Recommendation Report for Planning Permission for Works or Extension to a Dwelling

REF NO: Y/17/19/HH

LOCATION: 8 Mill View Road
Yapton
BN18 0JL

PROPOSAL: Two storey rear extension

DRAWN BY Author	CHECKED BY Checker	DATE 11.02.19
SCALE (@ A1) 1 : 50	PROJECT NUMBER Project Number	
DRAWING NUMBER Sheet 1		REV

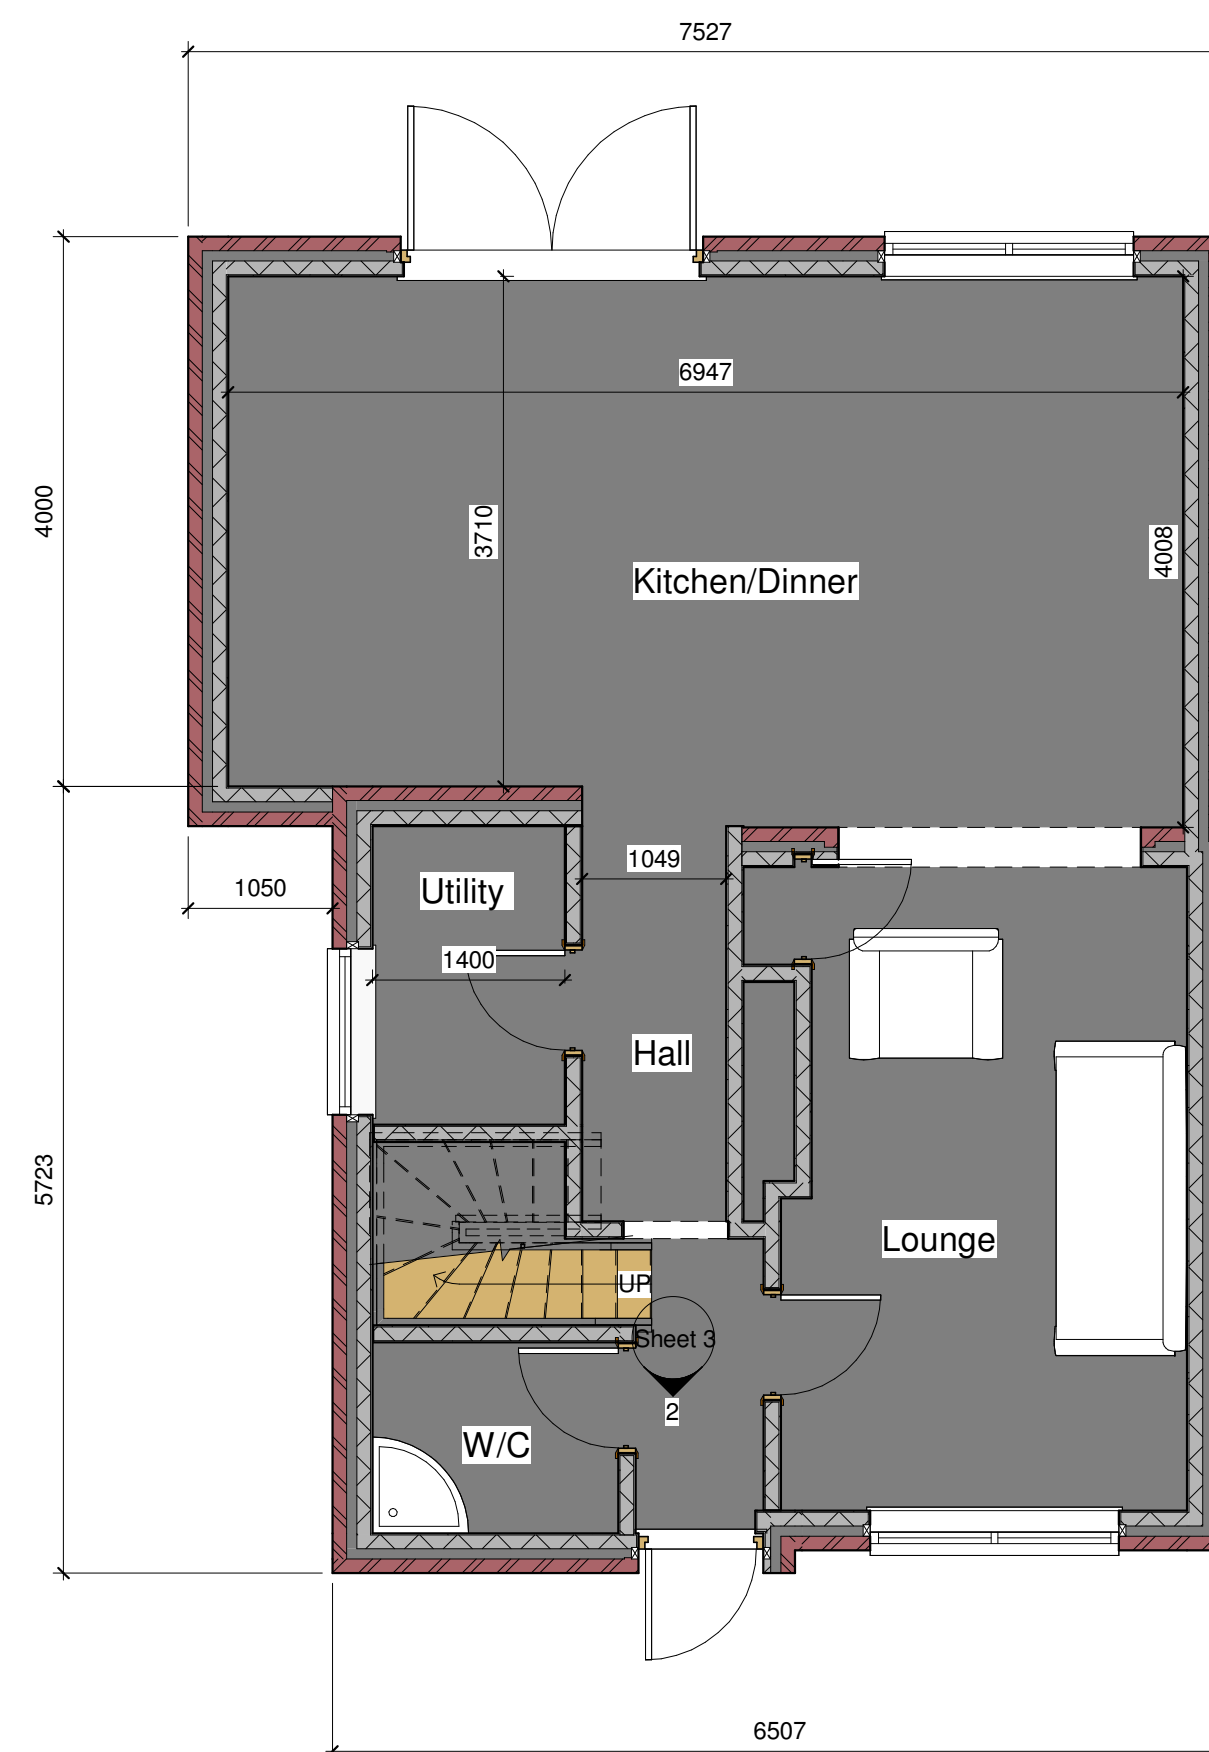
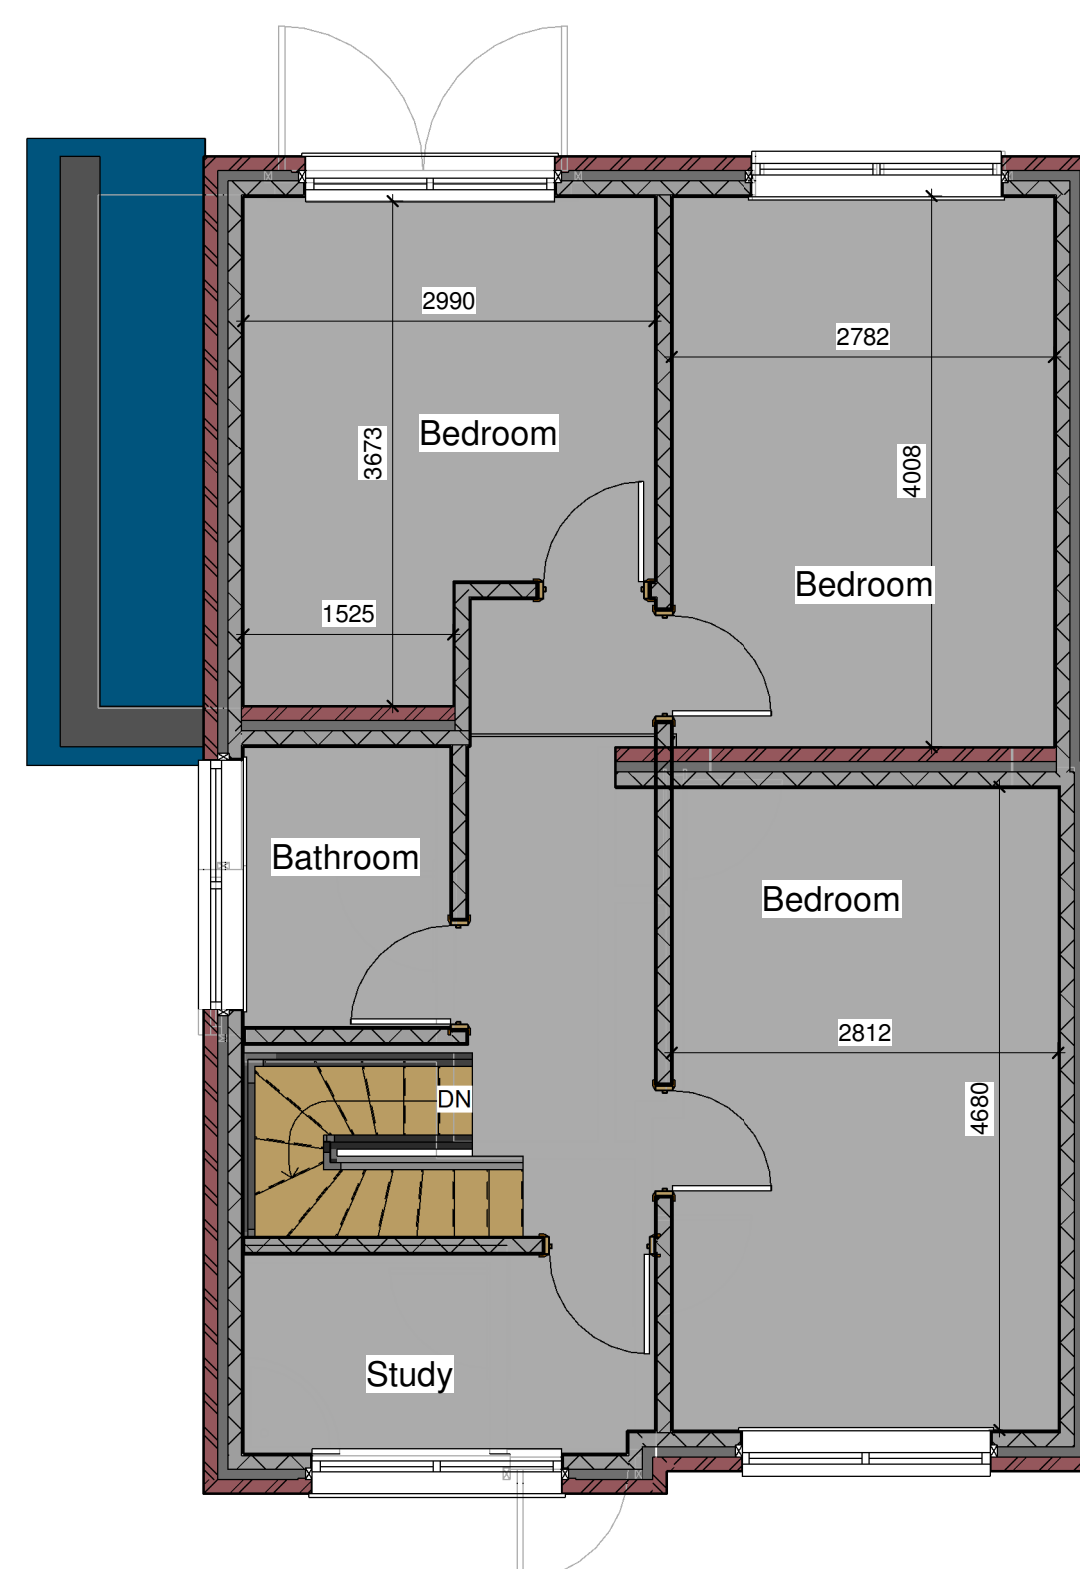
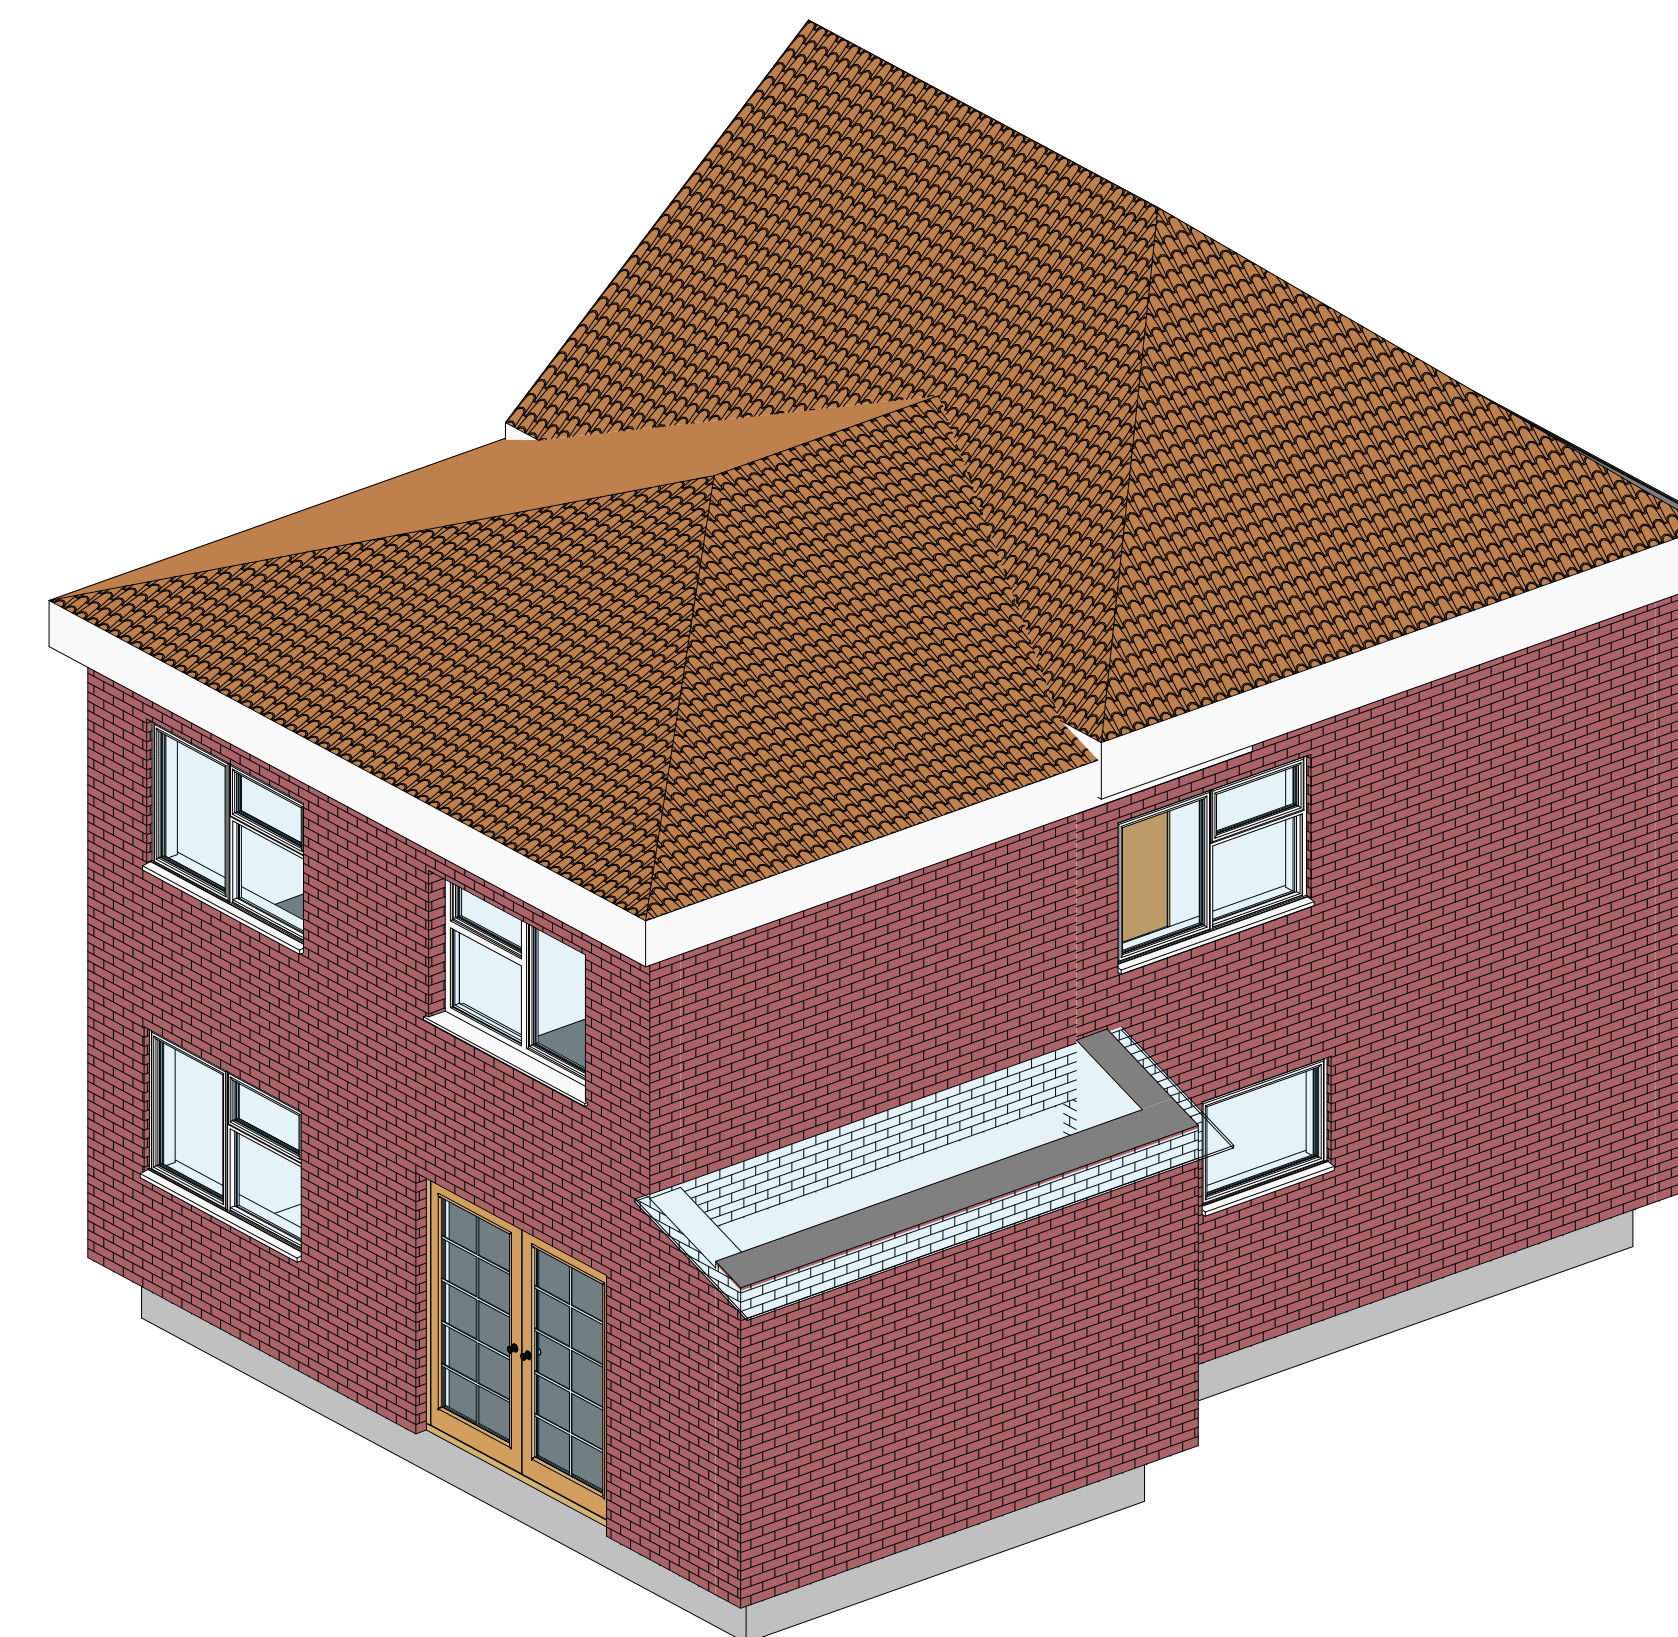
The two storey extension will have a depth of 4m and run along the full rear elevation. It will then reduce in height to a maximum of 2.7m with a lean to roof and extend a further 1.05m beyond the side elevation. The two storey element will have a hipped roof to a height of 6.1m to the ridge and eaves to 4.8m to match the host dwelling.

The council have adopted a 45-degree rule as a tool to balance the interest of those persons wishing to extend their premises and their neighbours by ensuring that extensions do not seriously impact upon neighbours outlook or daylight. In this instance the mid point has been taken of the neighbours window at first floor level and the proposed two storey extension conflicts with this rule.

As such it is considered that the proposed two storey extension would have an unacceptably adverse overbearing impact upon the first floor bedroom of No.7 Mill View Road. This is resultant of its failure to comply with the 45 degree rule and its close proximity to the first floor bedroom window, leading to an unduly dominant and overbearing impact and a loss of outlook to the occupiers of No.7.

To the western elevation the neighbouring property has a rear extension with a side window facing the host dwelling. Whilst the extension does reduce to single storey at this elevation, the window is likely to be impacted as a result of the depth of the two storey development and subsequently result in an overbearing impact.

- 1 Due to the size and siting of the two storey rear extension it is considered that the development will be unduly dominant upon and lead to an overbearing and unneighbourly
